**KIRKLEES METROPOLITAN COUNCIL
INVESTMENT & REGENERATION SERVICE**

DELEGATED DECISION TO DETERMINE PLANNING APPLICATIONS

Reference No:	2023/62/93664/E
Site Address:	Four Winds, 2, Highbridge Lane, Skelmanthorpe, Huddersfield, HD8 9JY
Description:	Erection of extensions and alterations (modified proposal)
Recommending Officer:	Elenya Jackson

DECISION - REFUSED

title GA as Existing - showing fallback position
number 22014D-05-P01
scale 1:100
size A1

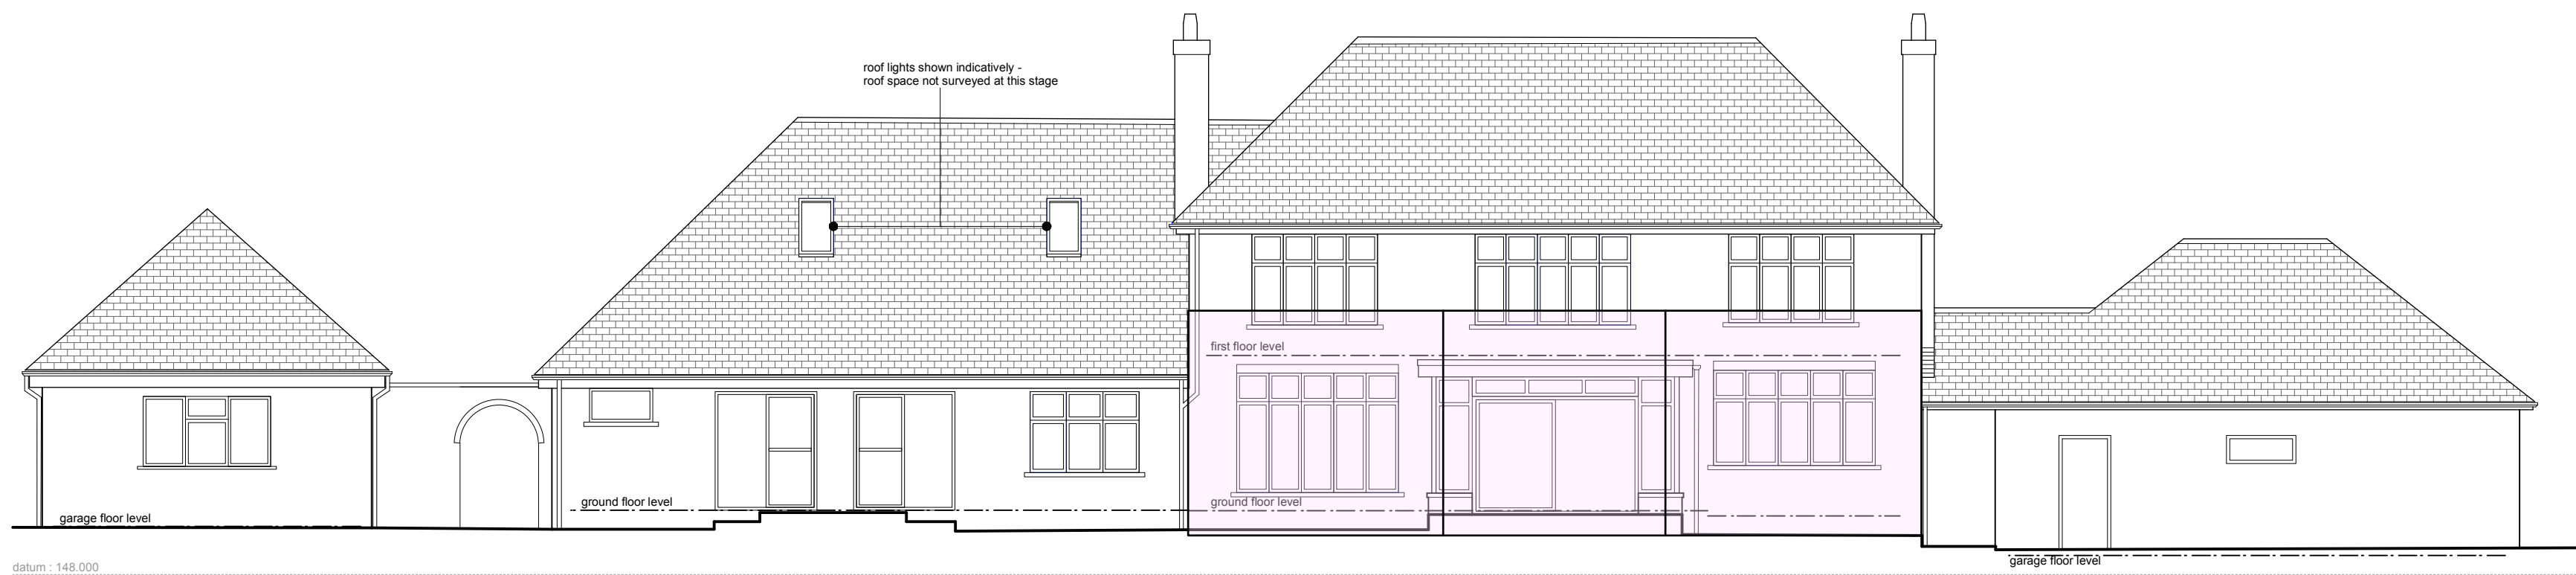
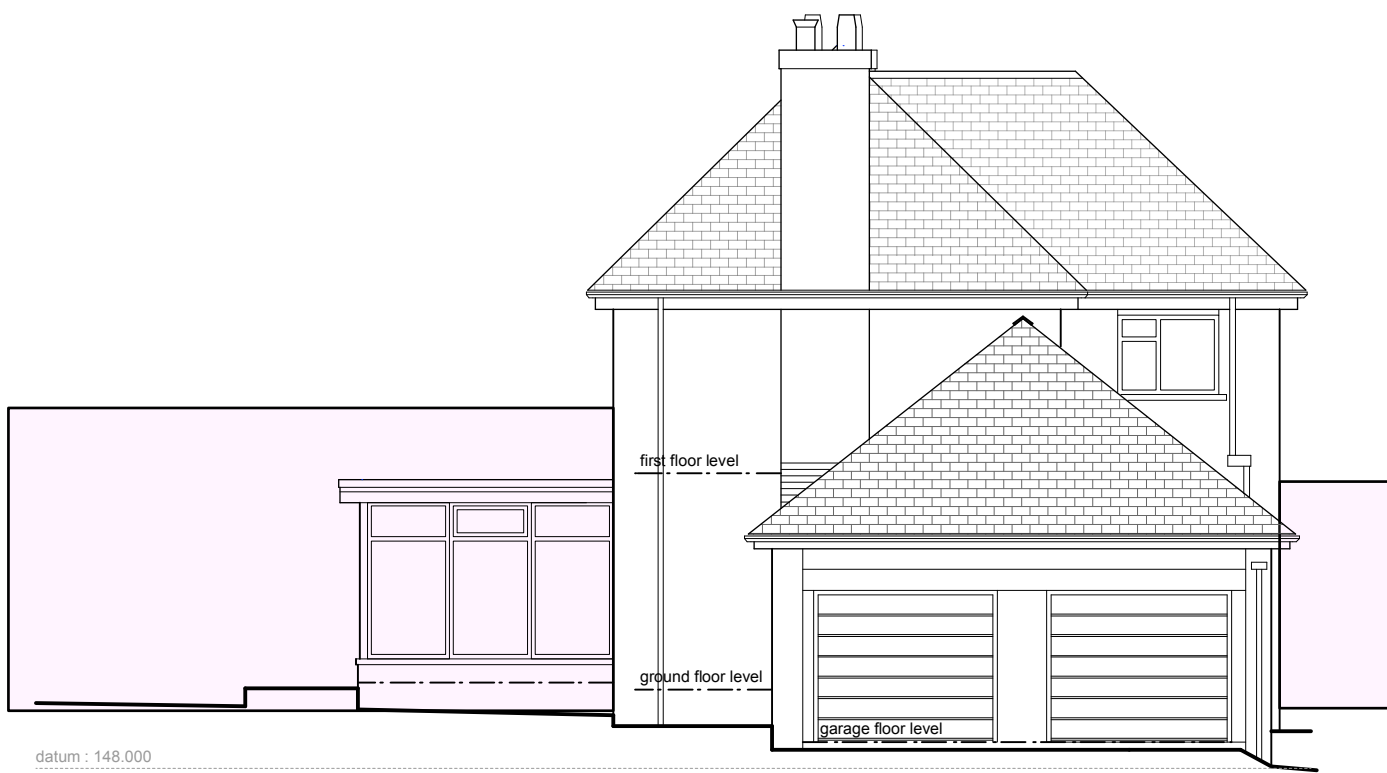
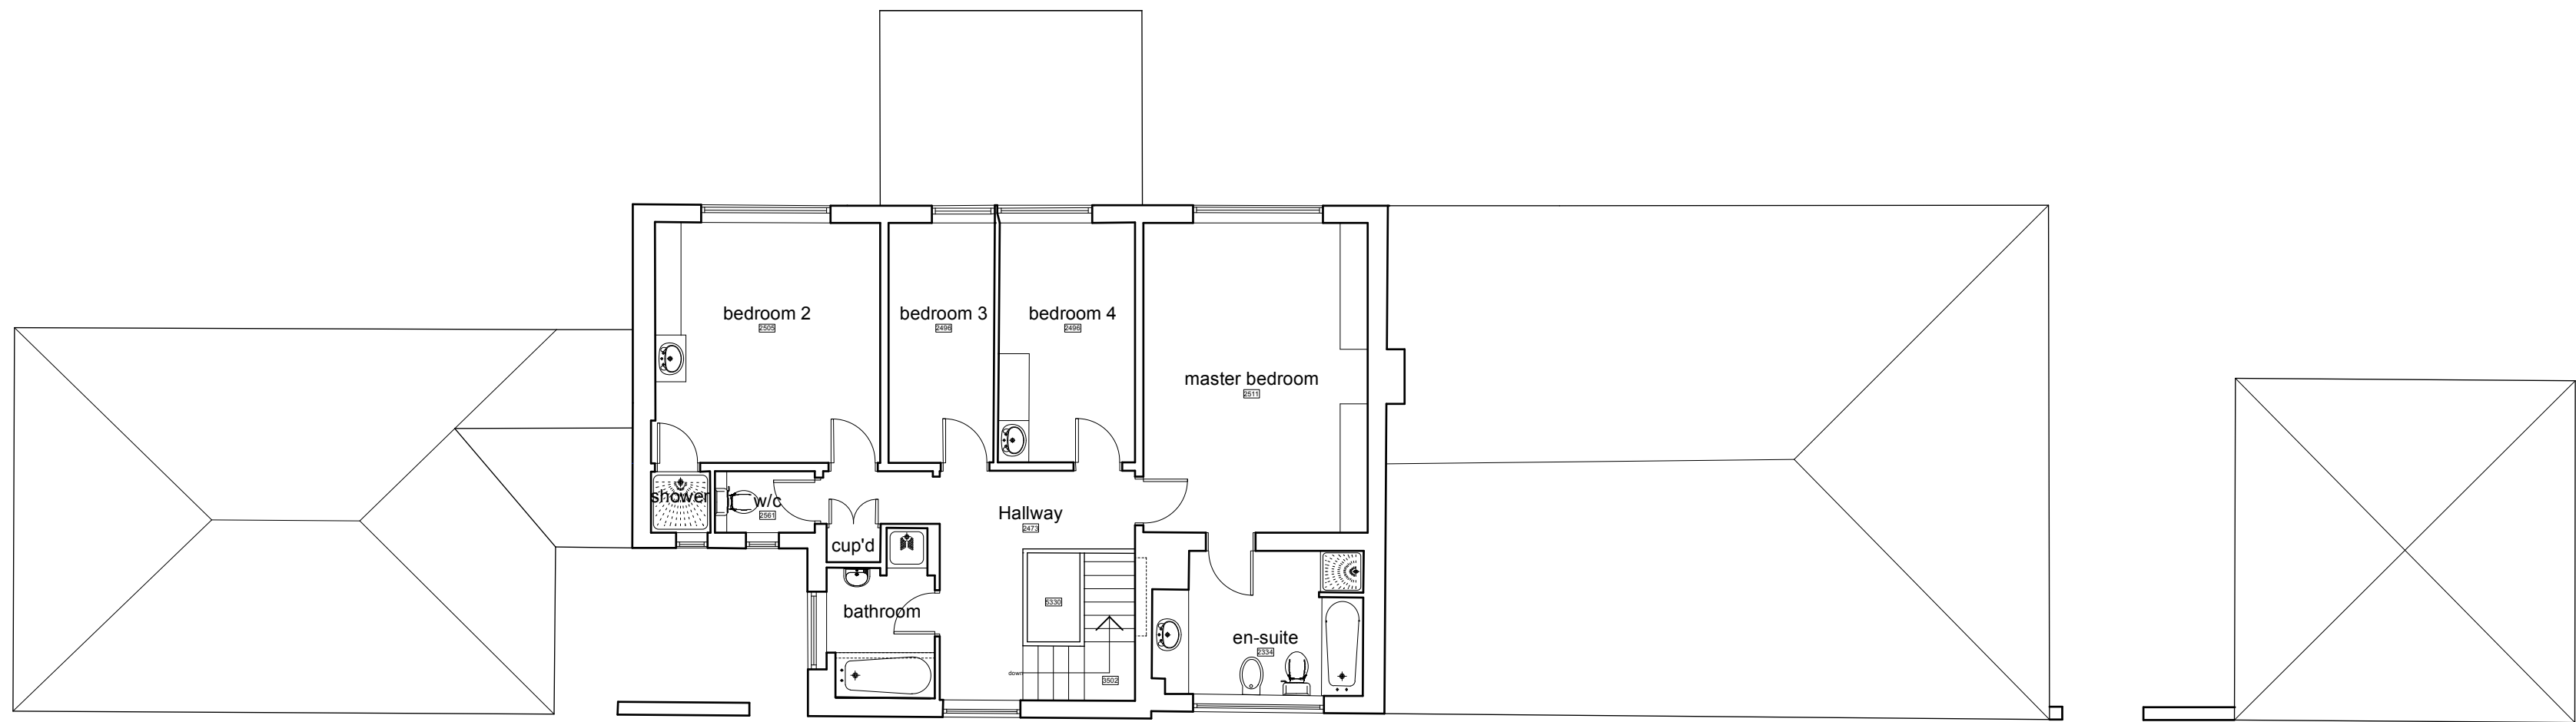
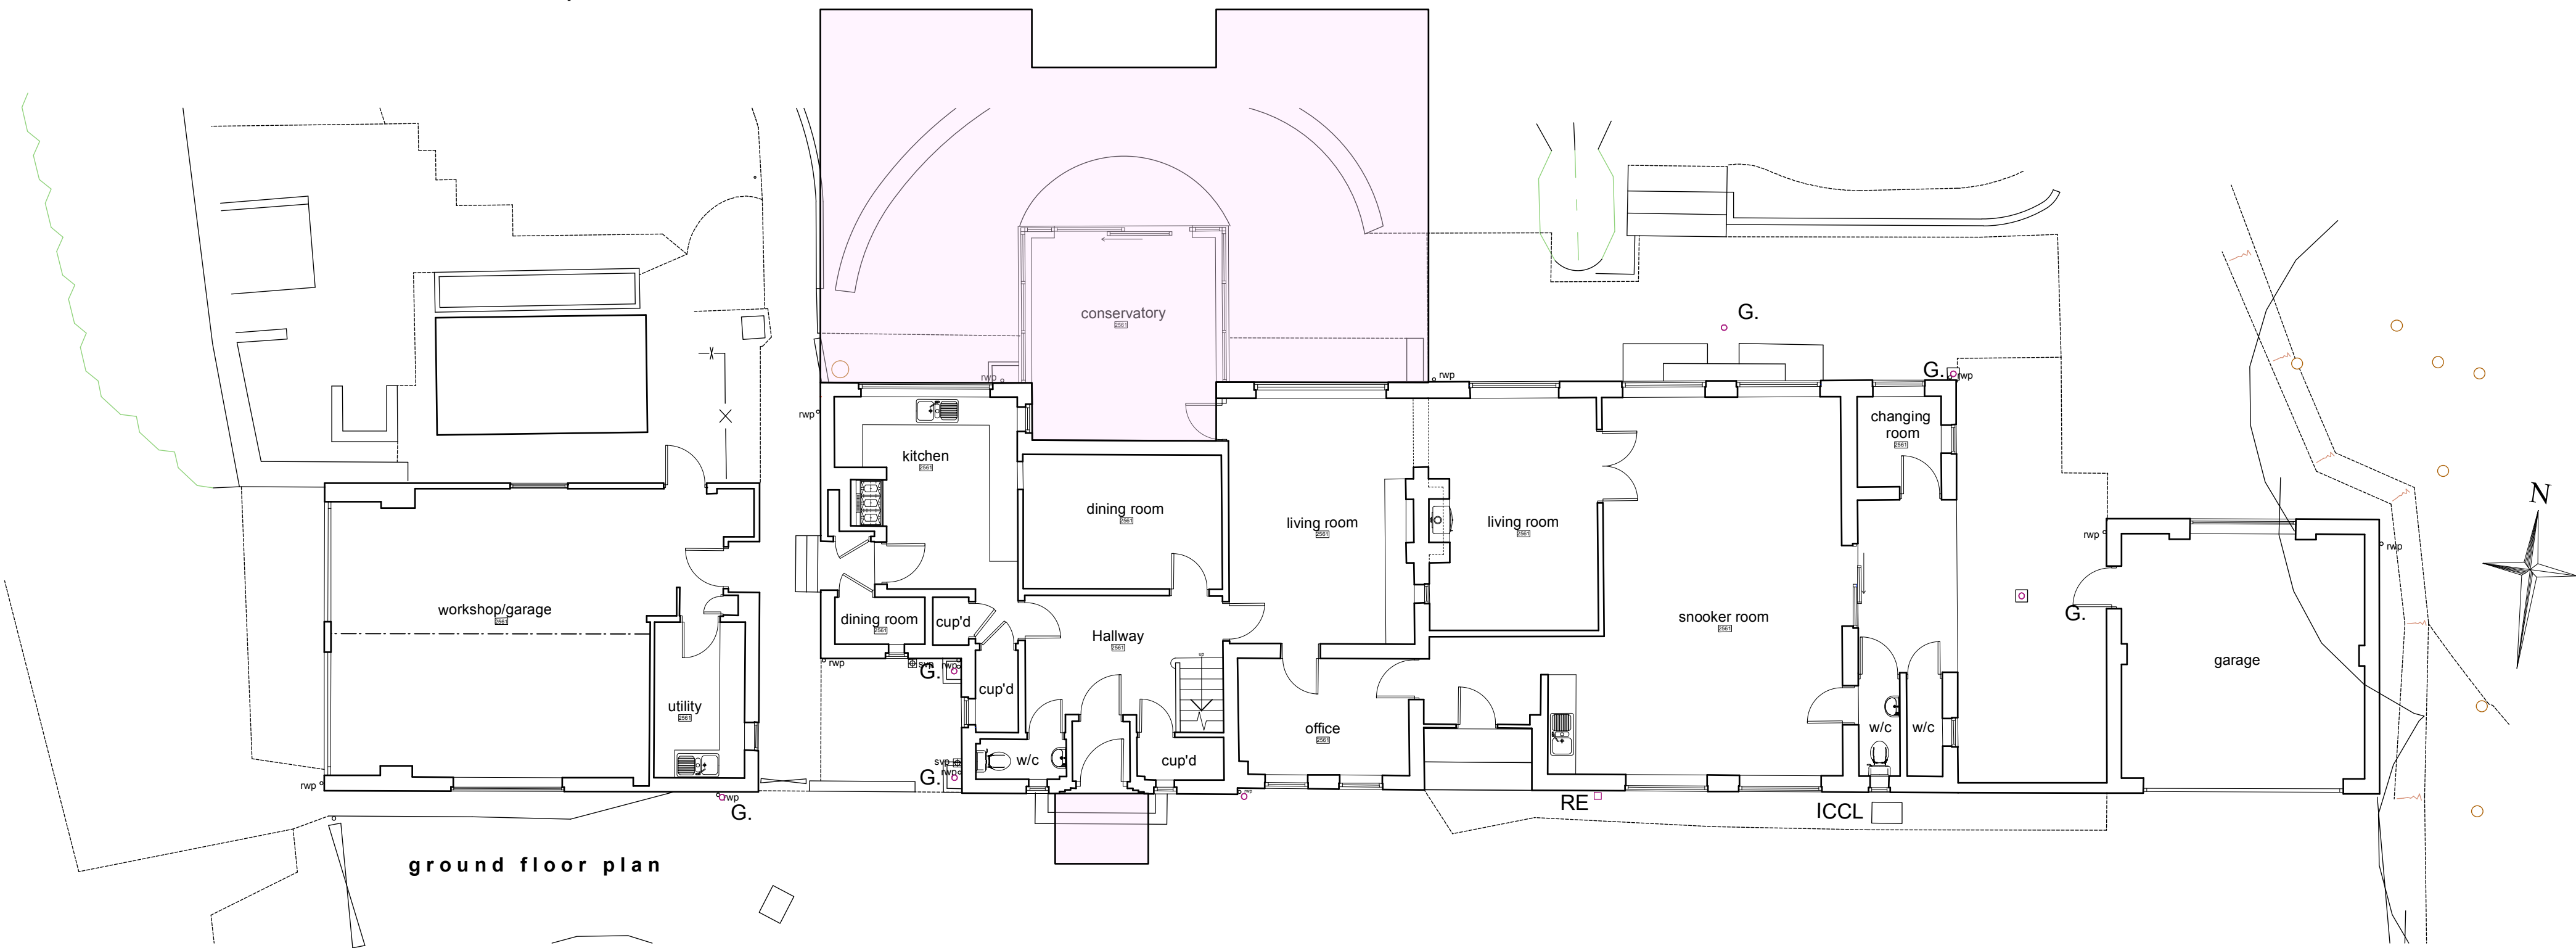
As previously highlighted, inappropriate development is, by definition, harmful to the Green Belt and should not be approved except in very special circumstances. When considering any planning application, local planning authorities should ensure that substantial weight is given to any harm to the Green Belt. 'Very special circumstances' will not exist unless the potential harm to the Green Belt by reason of inappropriateness, and any other harm resulting from the proposal, is clearly outweighed by other considerations. Very special circumstances have been submitted to accompany the application. The case has been provided that the applicant could construct a single storey rear extension of 8m as permitted development. There is no site

history for a larger home notification at this address and therefore it is considered there is no lawful fall back position, as such minimal weight can be afforded to this justification.

As 'harm' to the Green Belt must be assessed against both spatially and visually, it is considered that if a larger home notification was to be submitted, these alterations would be to the rear of the property and not as visually prominent within the Green Belt as the scheme received by officers. It is considered that these matters do not demonstrate very special circumstances to approve the application in its current form and would not be sufficient to outweigh the harm to the Green Belt.
